Question:	Question to:	Question:	Response:
Q1.1.6	Lincolnshire County Council	<p>Central Lincolnshire Local Plan Review</p> <ol style="list-style-type: none"> 1) Can Lincolnshire County Council please provide an update in respect of the progress of the Central Lincolnshire Local Plan Review and its progress towards adoption? 2) Should this change during the Examination Lincolnshire County Council should inform the Examining Authority (ExA) of any change in status at its earliest convenience. 	<p>Whilst this question is more appropriate to West Lindsey District Council it is confirmed that the Central Lincolnshire Local Plan was adopted in April 2023.</p>
Q1.1.21	Lincolnshire County Council, Nottinghamshire County Council, West Lindsey District Council, Bassetlaw District Council, Environment Agency, Natural England, Historic England, Lincolnshire Wildlife Trust, and any other Interested Party.	<p>Management Plans</p> <p>The Applicant has submitted the following outline management plans:</p> <ol style="list-style-type: none"> i) Outline Battery Safety Management Plan [APP-222] ii) Framework Construction Environmental Management Plan (fCEMP) [APP-224] iii) Framework Operational Envir

AECOM

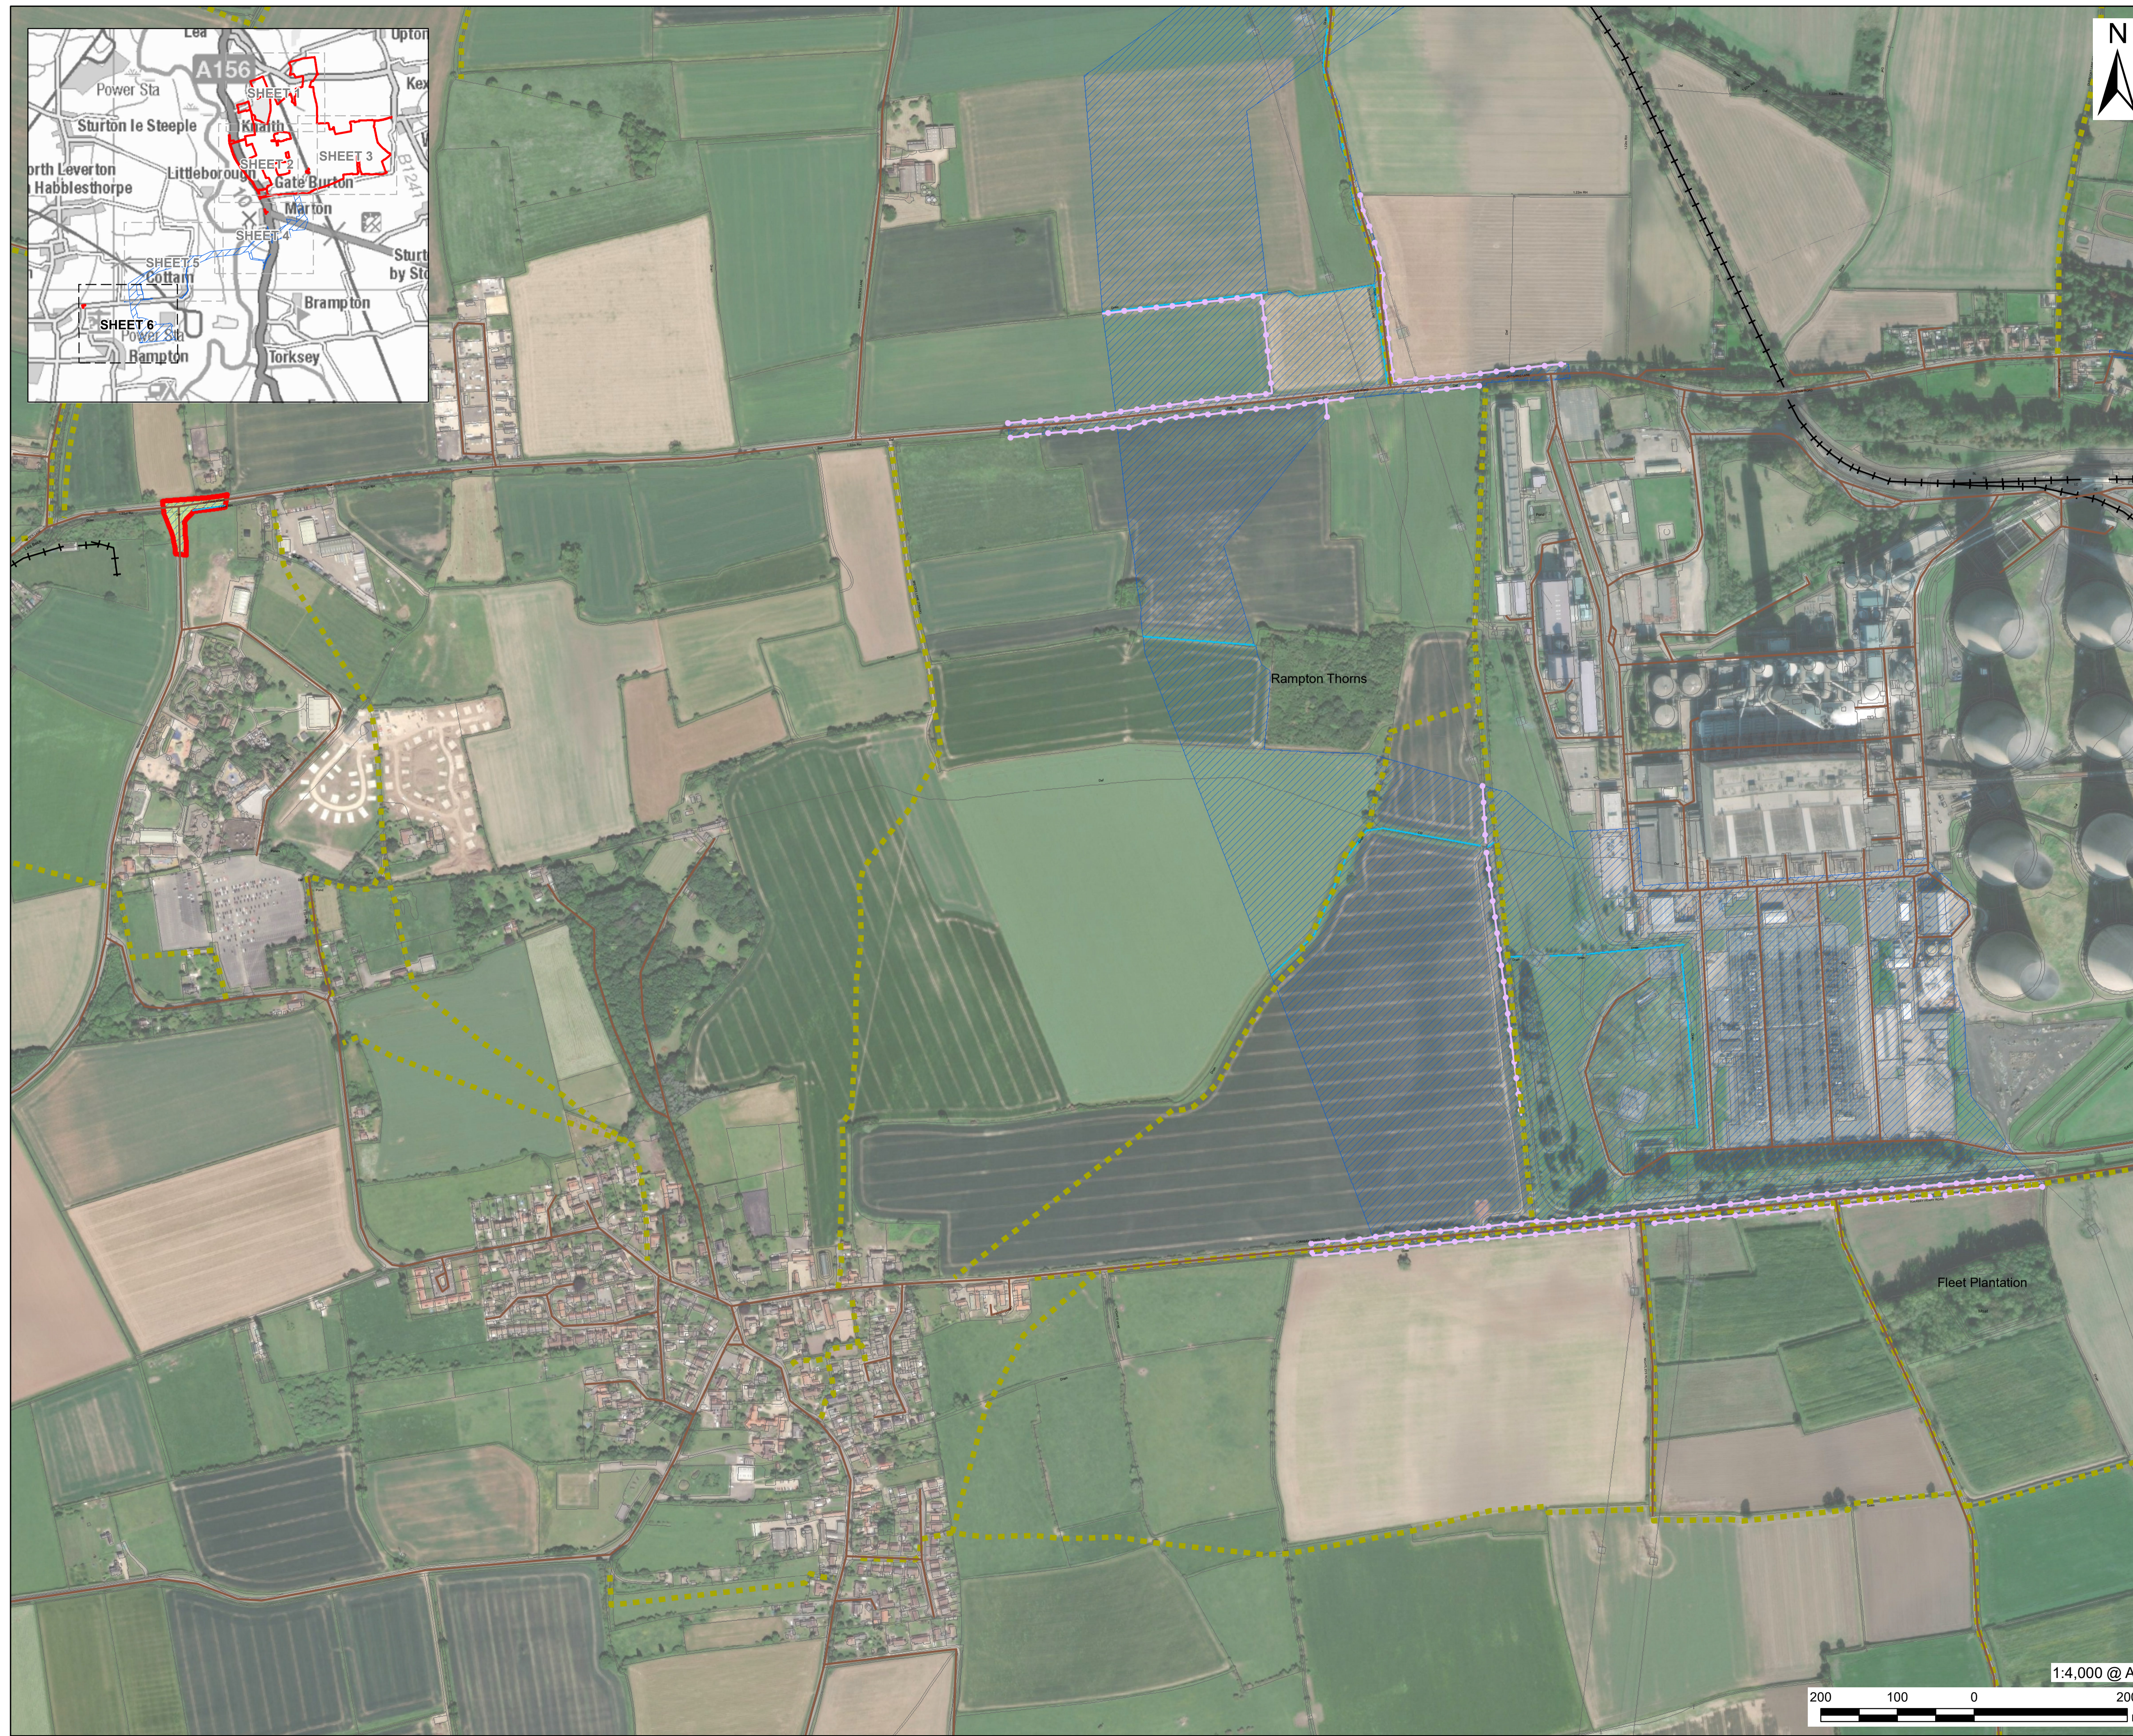
The success of the landscape mitigation to meet the objectives laid out in the management plan to integrate and screen proposals, promote conservation and protection of the environment and ecological and habitat diversity is highly dependent upon the successful management and maintenance of the new planting, as well as protection of exiting trees and hedgerows. The maintenance operations provide an initial overview of operations; however we would expect the management plan be developed further and also last well beyond the initial 5 year period, particularly if landscape and visual effects are being assessed at 15 years: the reduction in landscape and visual effects presented in the LVIA are based on the success of landscape mitigation. Similarly, any early planting should be secured and implemented at the earliest opportunity as effects are also reduced in the LVIA based upon the assumption these are in place and have established as planned.
